PLANNING CONSULTATION RESPONSE

Application No	2026/0881
Proposal	2026 0881 Proposed First Floor Side Extension Old Estate Office Lowe Lane Stainborough
Address	Old Estate Office Low Lane Stainborough
Date of Consultation Reply	211026
Consultee	Tony Wiles Senior Conservation Officer

Consultation Response Conservation

PRO PLANS & ELEVATIONS

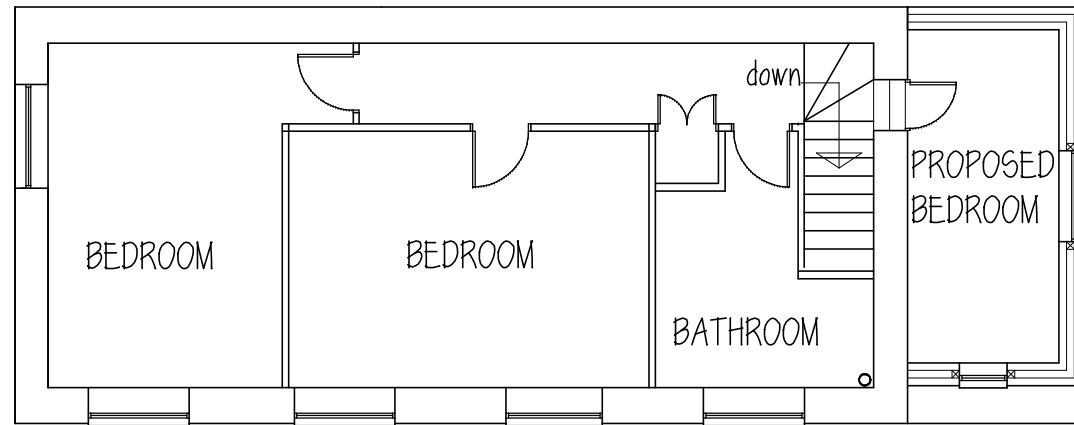
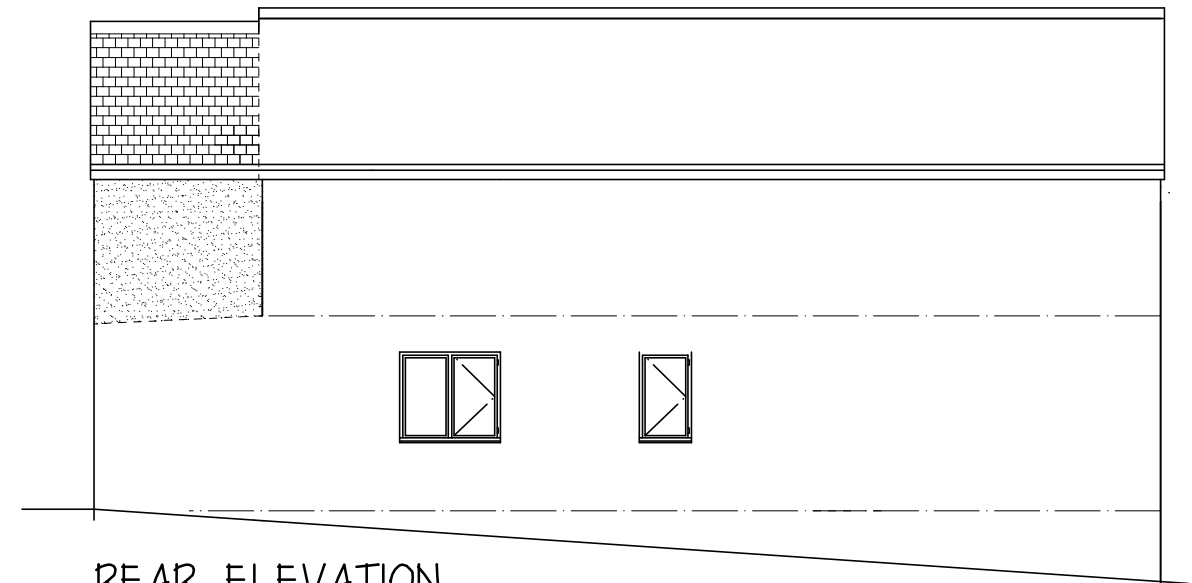
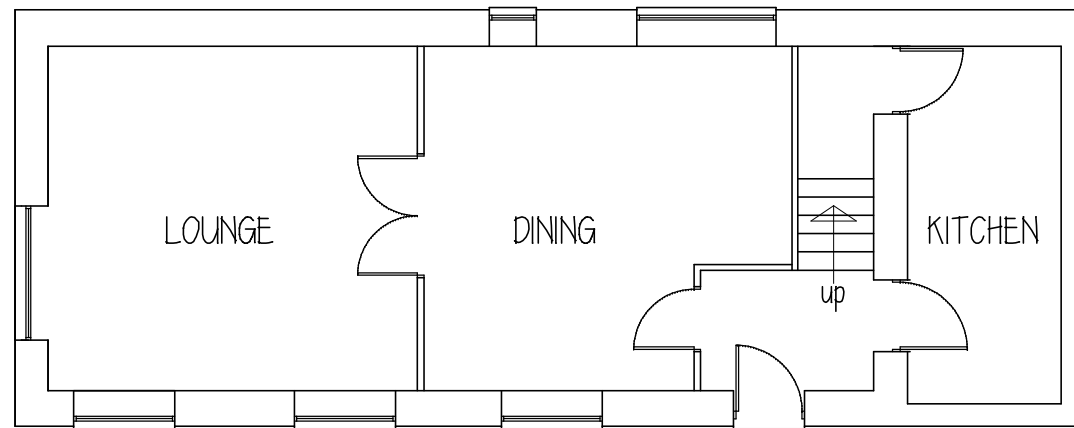
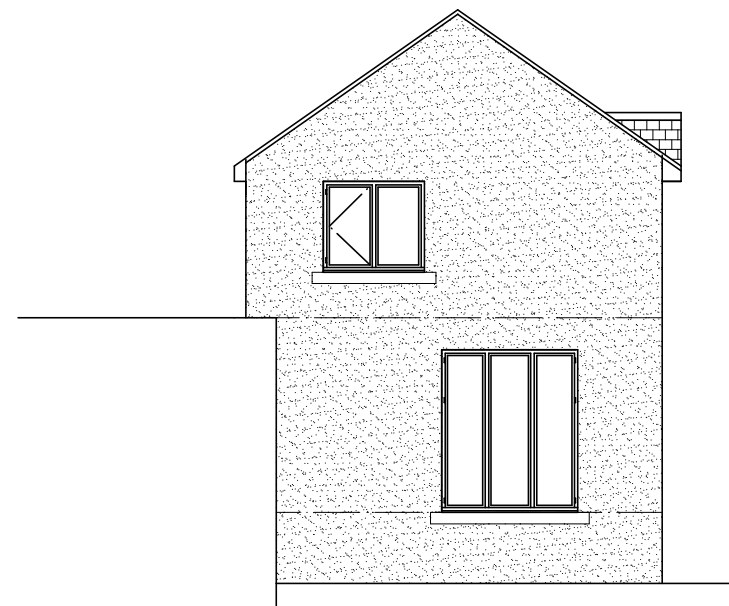
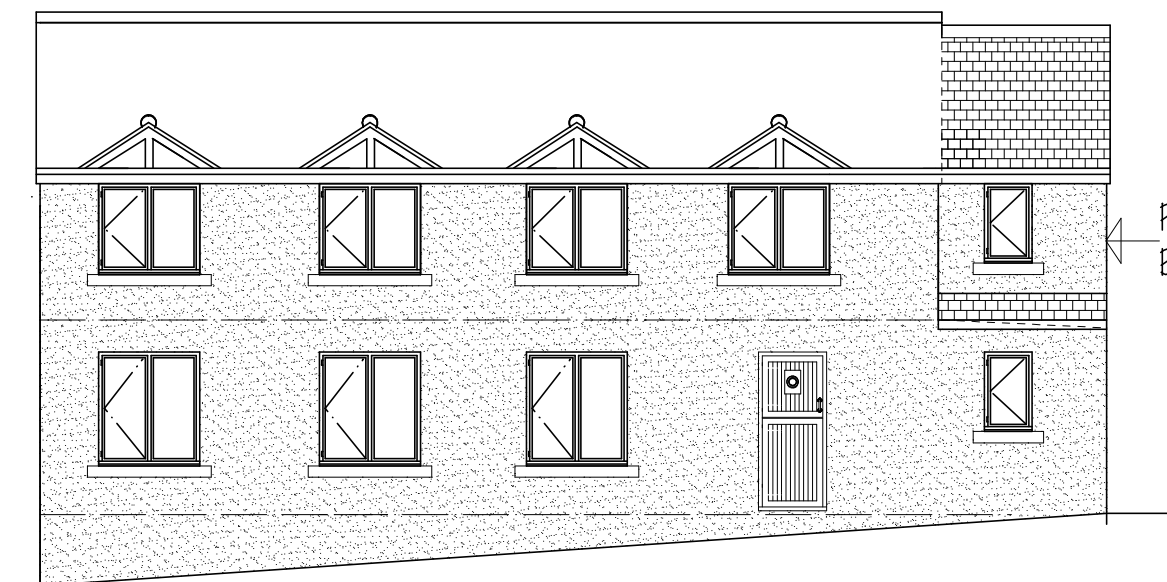
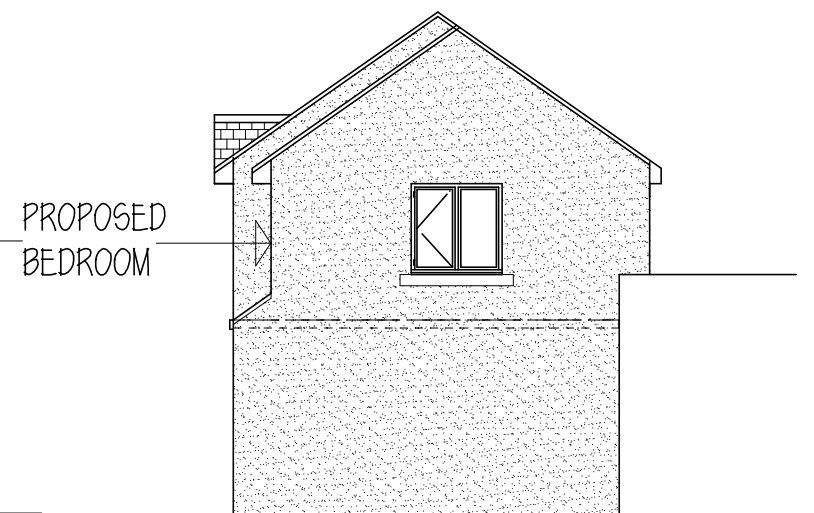
In terms of the proposal, this would add a pitched-roof first-floor extension above the existing shallow-pitched, single-storey lean-to on the western gable, which currently accommodates the kitchen. The new first-floor room would form a bedroom, accessed through the existing gable window opening, which would be extended down to floor level. The dwelling will retain three bedrooms overall because the dividing stud wall between two existing bedrooms would be removed to create one larger room. External works include replacement uPVC windows and doors throughout, conversion of the east-facing ground-floor window to French doors, and three new windows: one at ground-floor level serving the kitchen and two at first-floor level serving the extended bedroom. The application describes the existing windows as uPVC; they are in fact modern (later C20) timber units. The entire external envelope is proposed to be re-rendered.

In summary, the host building appears to have lost much of its heritage significance through later alteration, and the proposed extension is relatively modest. Nevertheless, there are concerns regarding the proposed materials and construction methods in the context of the conservation area and the Grade I registered park and garden, particularly the proposed uPVC windows and modern roof tiles. These details may require amendment to ensure that the development responds appropriately to its sensitive historic setting.
